**McWilliam's Winery Expansion (MP 09_0177)
Response to exhibition of Environmental Impact Statement**

Attachment A

Comment by NSW Office of Water

Figure 22- Map of Farms 195, 196 and 199 and proximity of current bore network

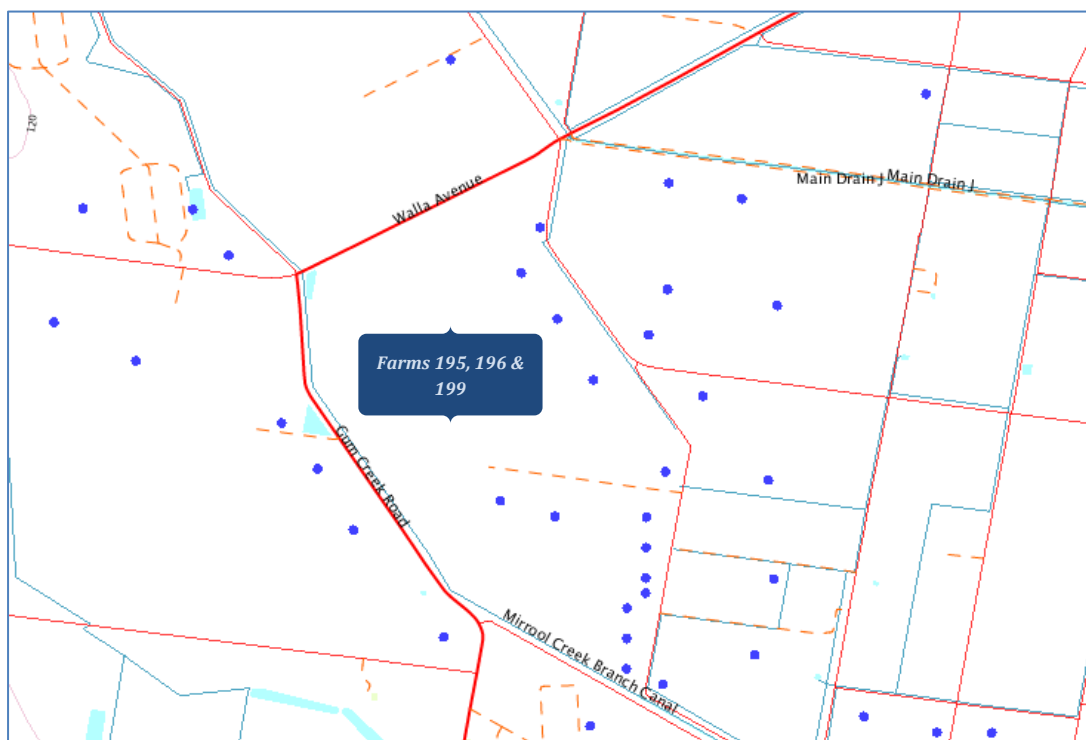
- (i) Although the Environmental Assessment (EA) provides significant detail about the regional groundwater levels, it only provides bore construction details for the Murrumbidgee Irrigation sites in the vicinity of the proposed development. Tables 10 and 11 identify bores in the area of the development but the associated figures (22 and 23) do not identify the bore numbers to enable them to be located.
